Planning Consultation Memo

Date	Planning Officer	Environmental Health Officer
12/08/15	Joseph Wharwood	Karl Riahi
Planning Application Number	Worksheet Number	
N6/2015/1309/FP	WK/71911

Address: The Parkway Bar, Parkway, Welwyn Garden City, AL8 6JQ

Application Details: Installation of bi-fold doors to front and rear elevations

<b>ENTERPRISE NNS</b> PROJECT THE PARKWAY WELWYN GARDEN CITY HERTFORDSHIRE AL8 6LD	
EXISTING AND PROPOSED ELEVATIONS SCALE 1:50 @ A1		DRAWING NO. 14136/ELP 102 DATE APRIL 2015

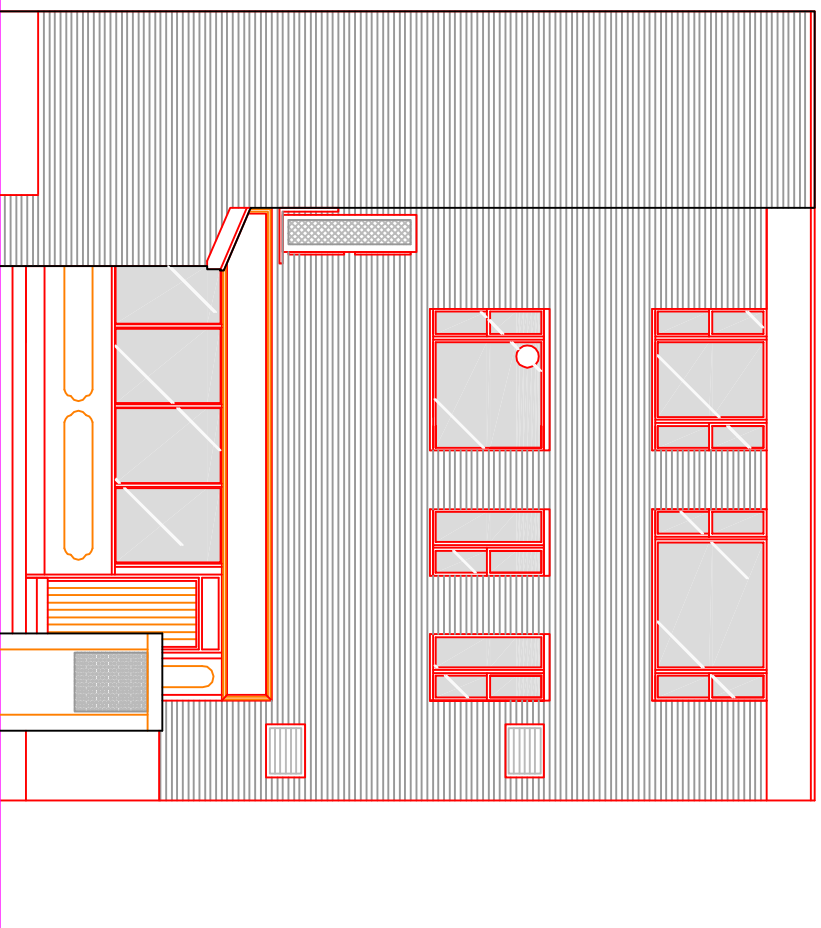
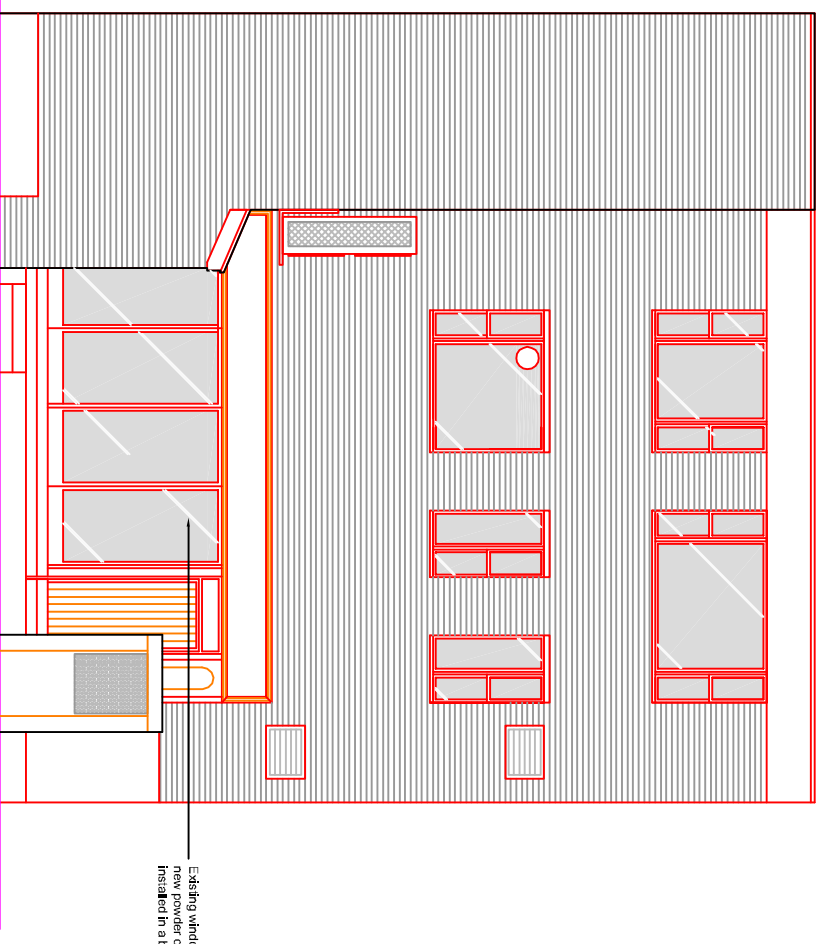
The frontage of the premises is already heavily glazed, the bi-fold doors when closed and if of a suitable specification could improve current sound insulation standards at the premises.

The glazing will need to be of a suitable standard to limit noise egress when the doors are closed, it is recommended that a condition requiring details relating to the sound insulation of the doors be submitted prior to works taking place. The applicant will need to ensure that the glazing specification limits noise break out and should

If live or recorded amplified music is to be played then it is recommended that a condition be placed on the application requiring the doors to be kept closed at any time. This is not a complete duplicate of the licensing condition as it includes all types of amplified music which with the doors open would be likely to cause disturbance.

The bi-fold doors are to be closed at all times during the performance of live or recorded music and at 2200hrs in all other cases.

Prior to the commencement of the development the applicant shall submit to, for approval in writing by the Local Planning Authority, a noise assessment which contains the noise insulation details relating to the glazing specification of the bi-fold doors and a comparison to the existing sound insulation of the premises.

The bi-fold doors to be installed must meet the criteria highlighted by the noise assessment.

Proposed Ground Floor Plan

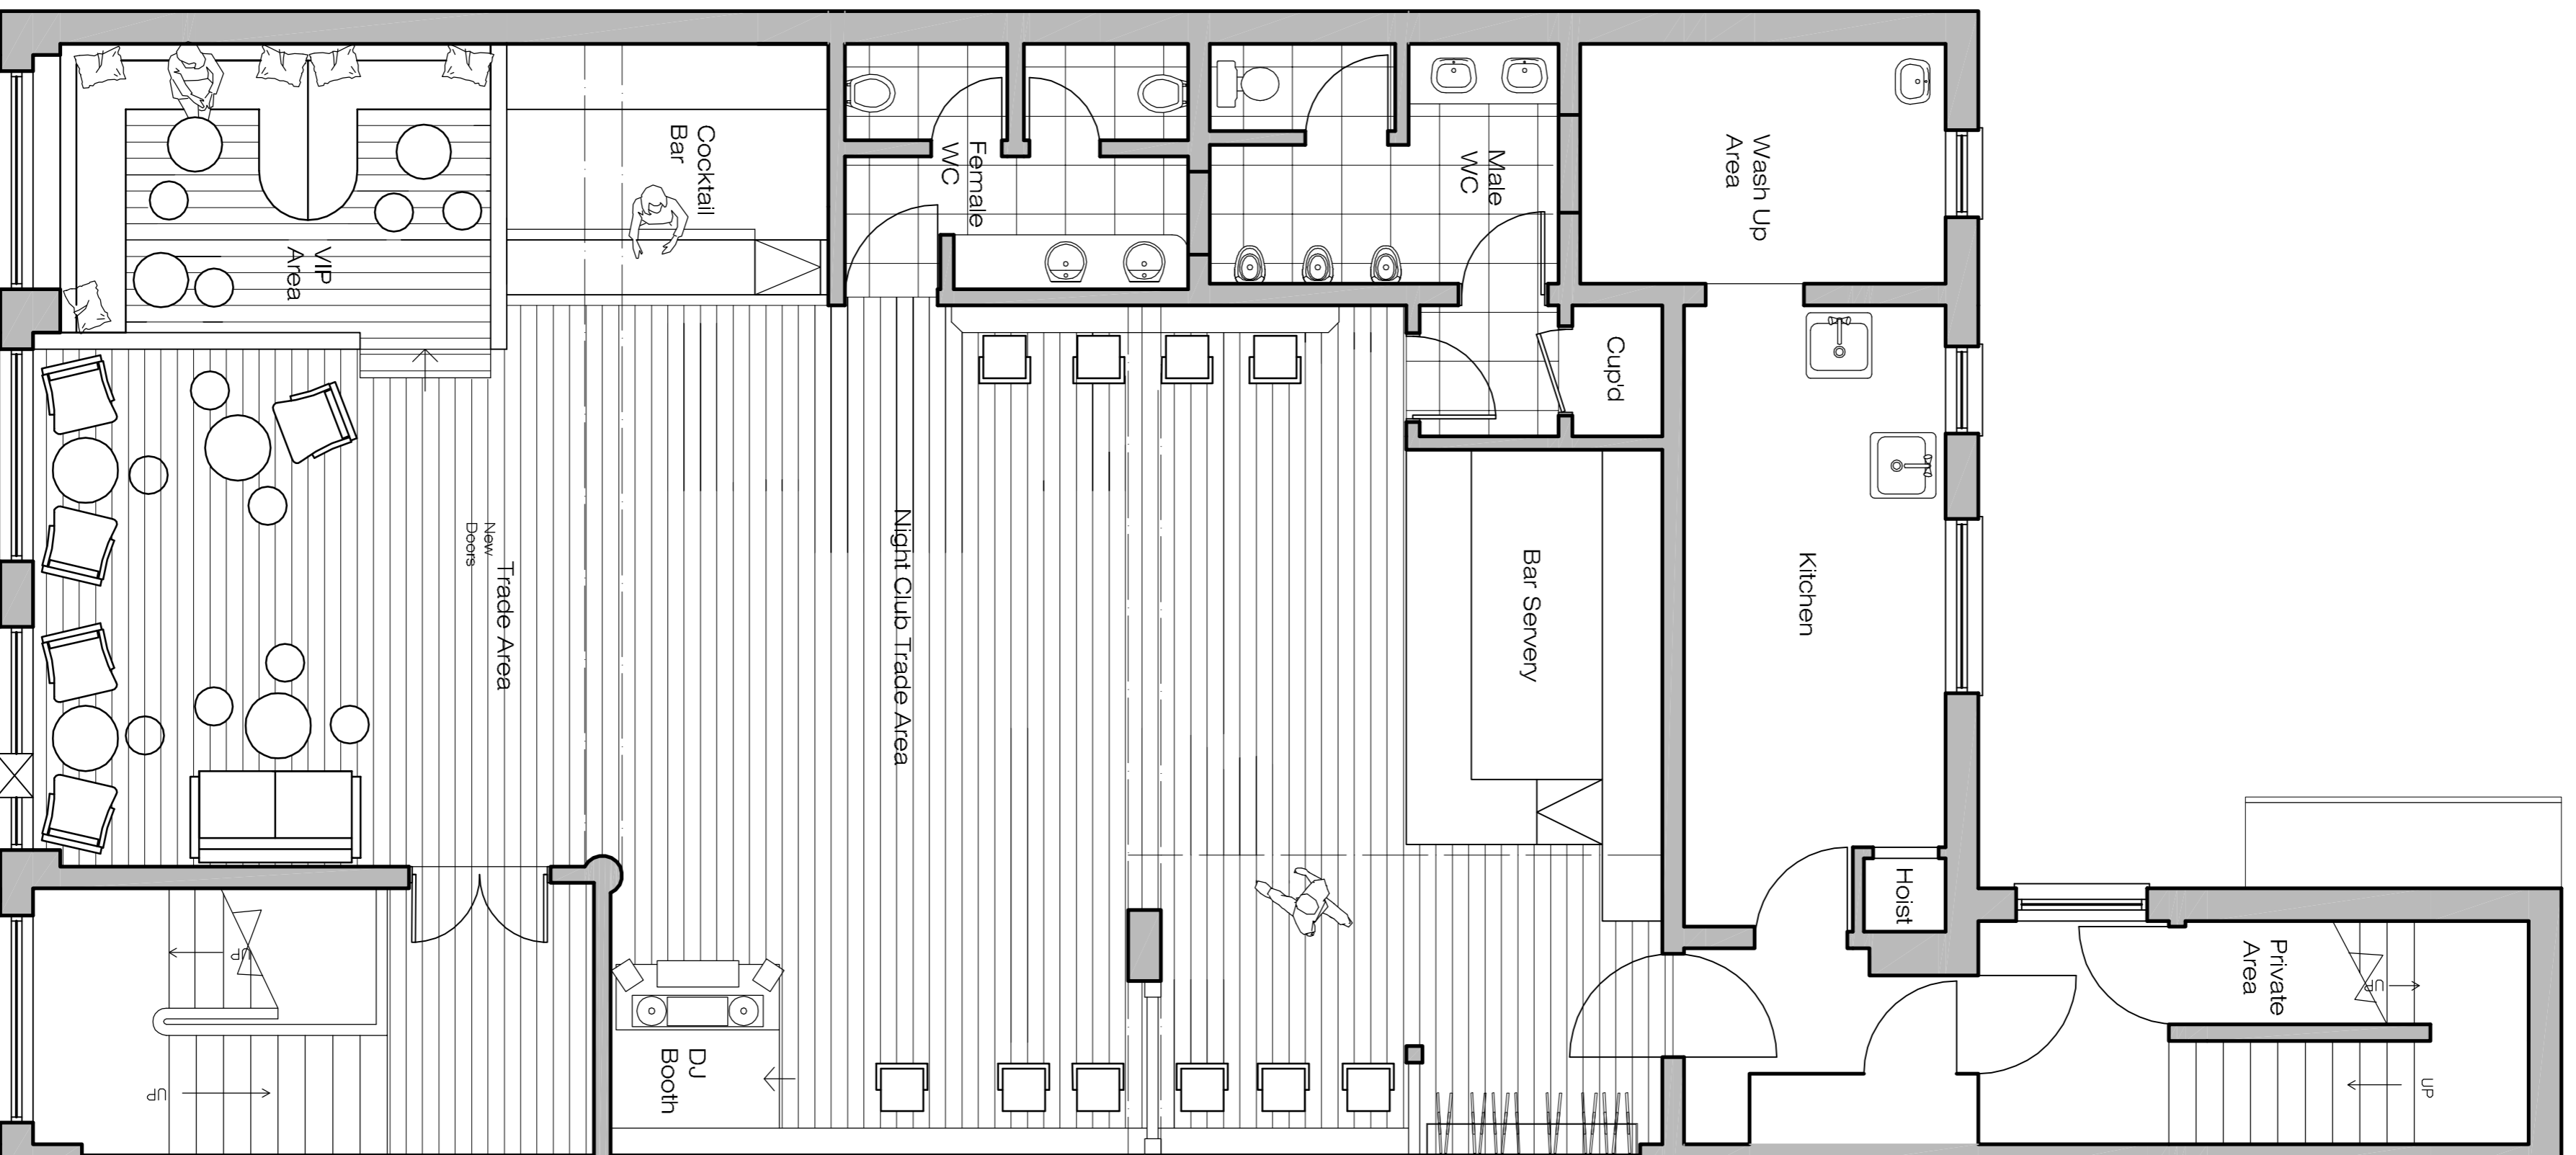
Doors are now being shown to be installed at the top of the stairs in Bar 67 which should help to reduce the current noise break out as there does not appear to be any current form of attenuation in this area of the premises.

ensure that it is able to attenuate low frequency noise associated with music played at the premises. In confirming the above, the applicant will need to conduct a noise assessment to show that the sound insulation is not compromised due to the proposed changes to the premises. The applicant is advised to aim for 10dB below background at the nearest residential properties for noise egress from the premises with the doors closed.

Doors to be kept closed

Sound insulation – glazing specification
